Application for a non-material amendment following a grant of planning permission.

Planning Application - Conversion of barn to form 1 no. dwelling and erection of glasshouse and store

Amendment to cladding and minor fenestration changes to scheme approved under DC/20/3633 and DC/20/3634

Vertical Boarding Sections 1.2

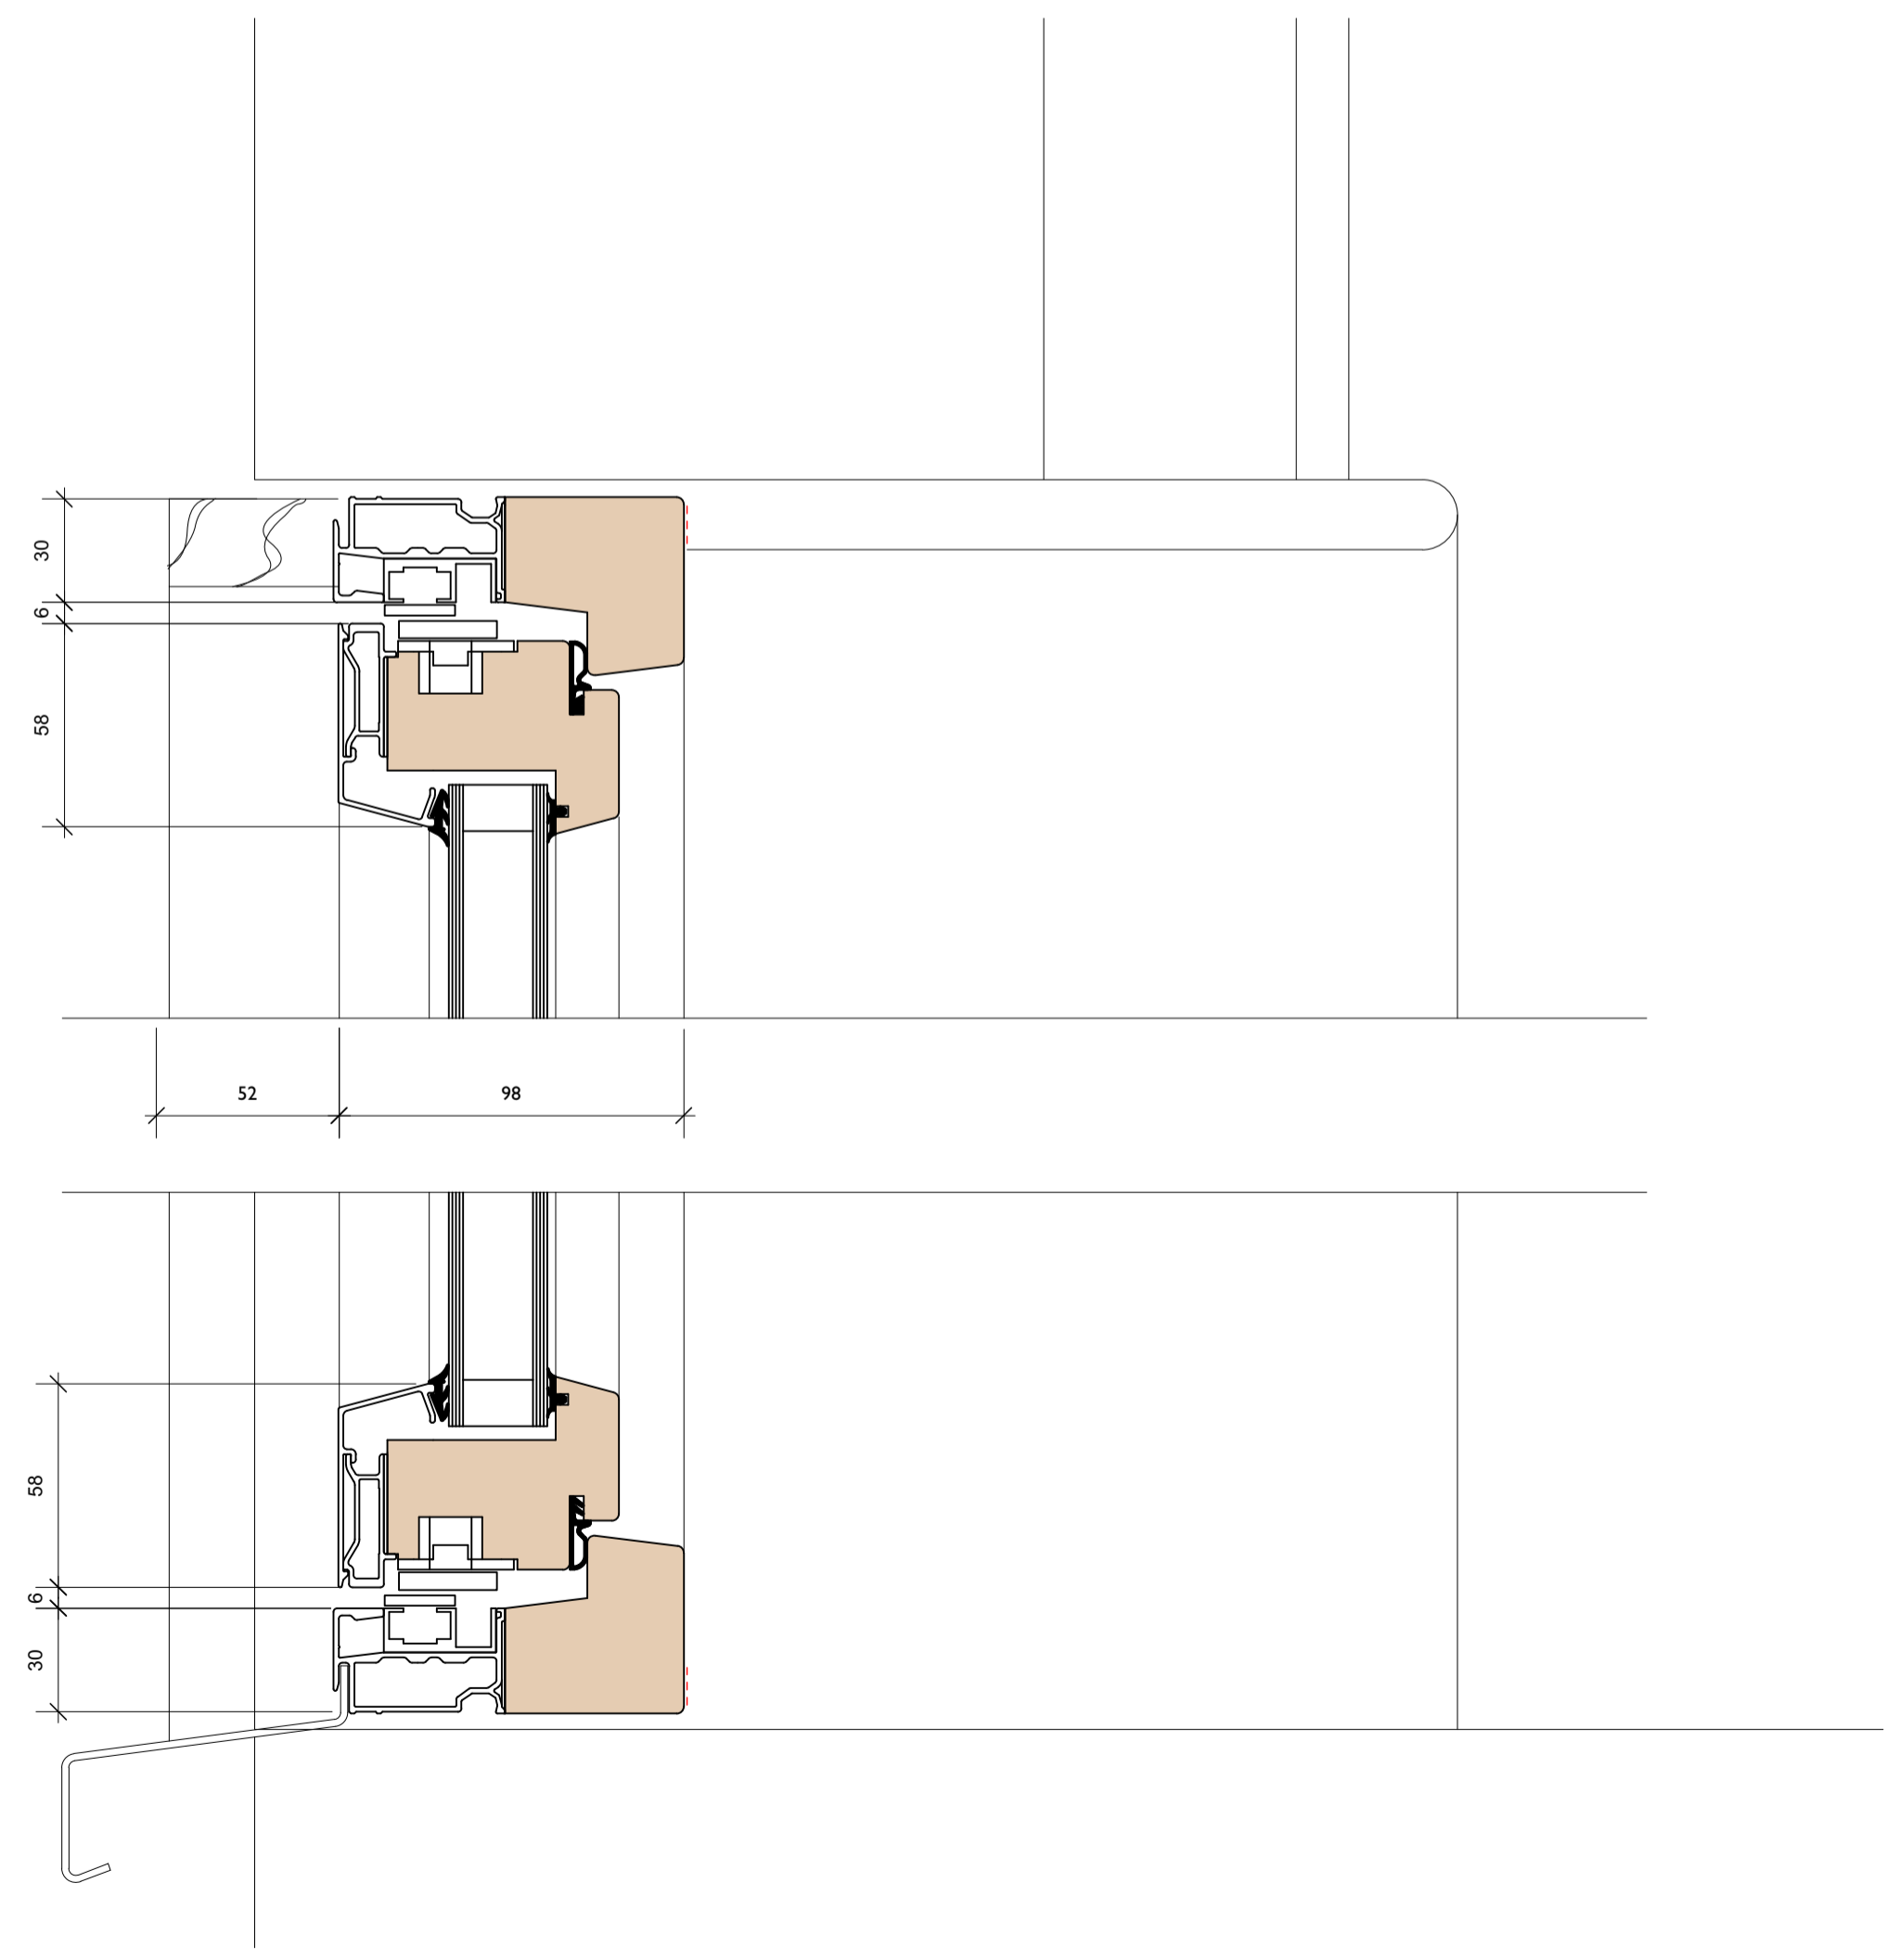
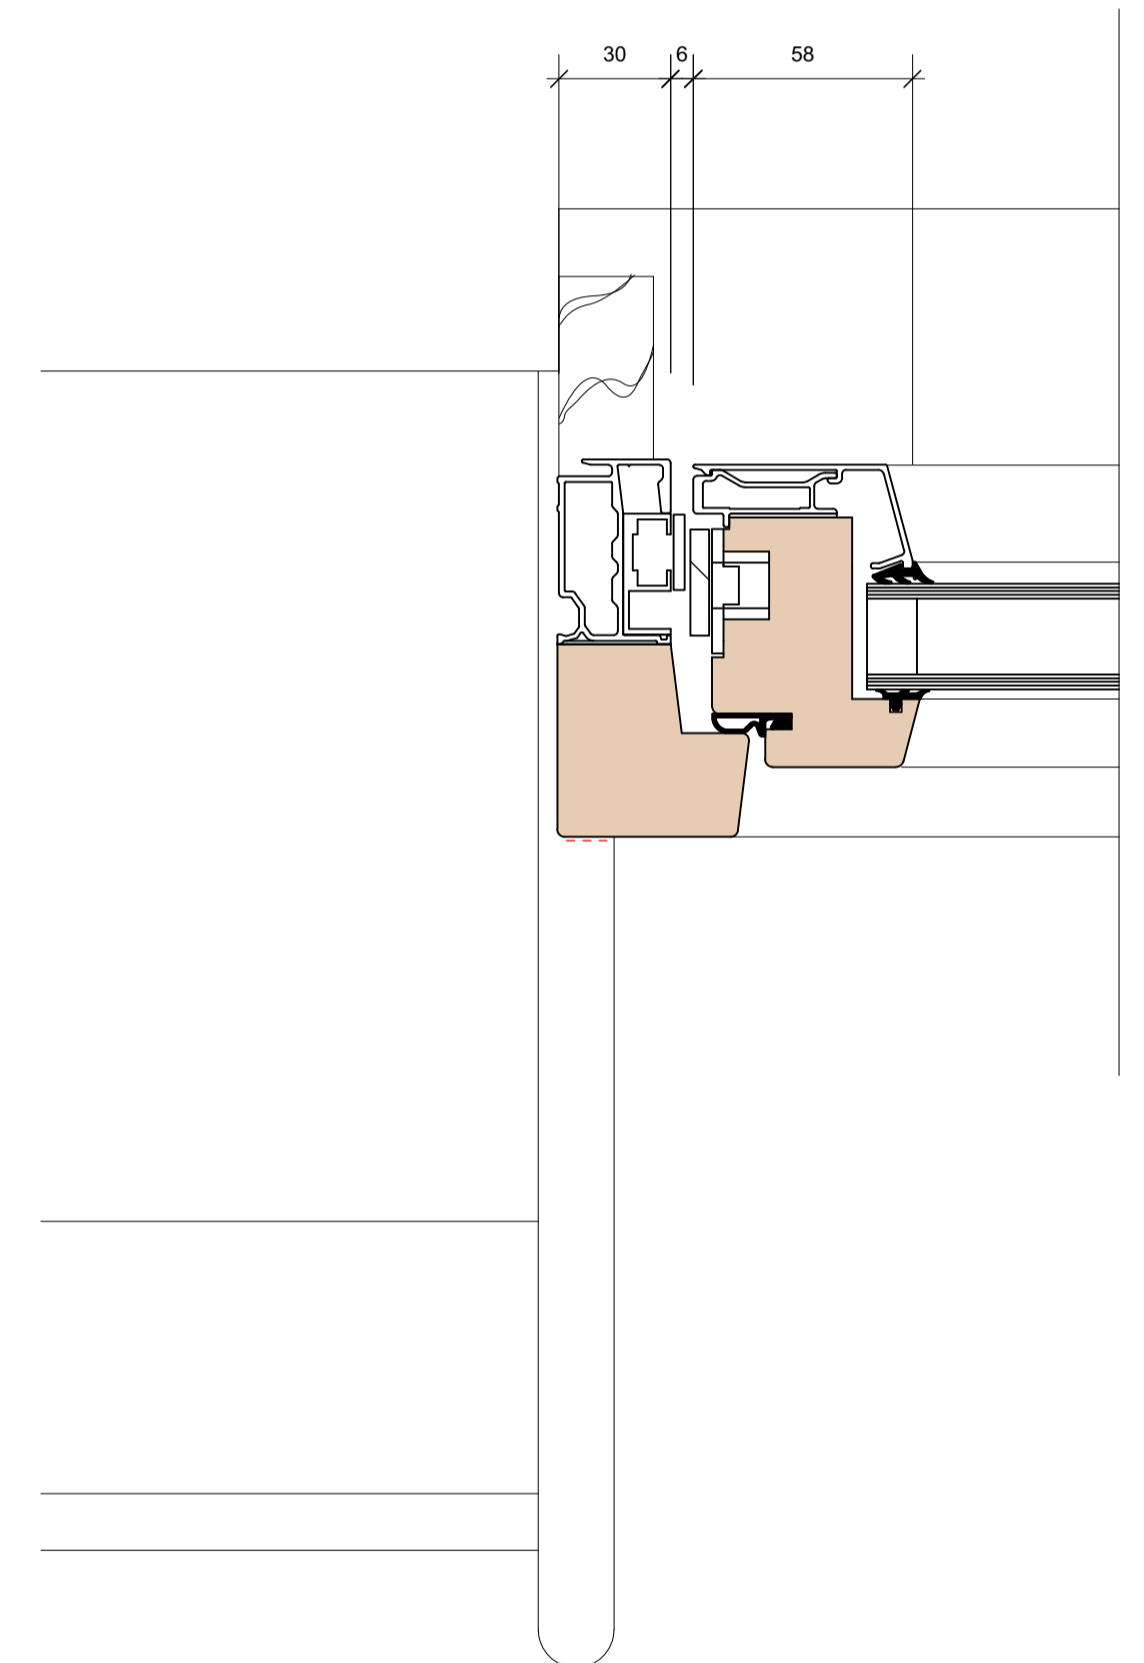
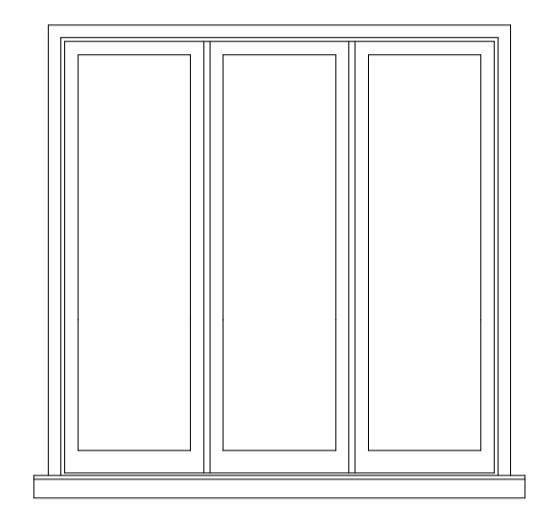
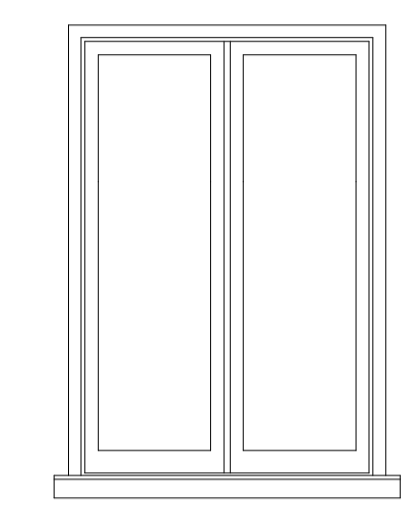
TO1 - 11 - Elevations 1
TO1 - 12 - Elevations 2
TO1 - 08 - Joinery

TO1 - 11 A - Elevations 1
TO1 - 12 A - Elevations 2
TO1 - 08 A - Joinery
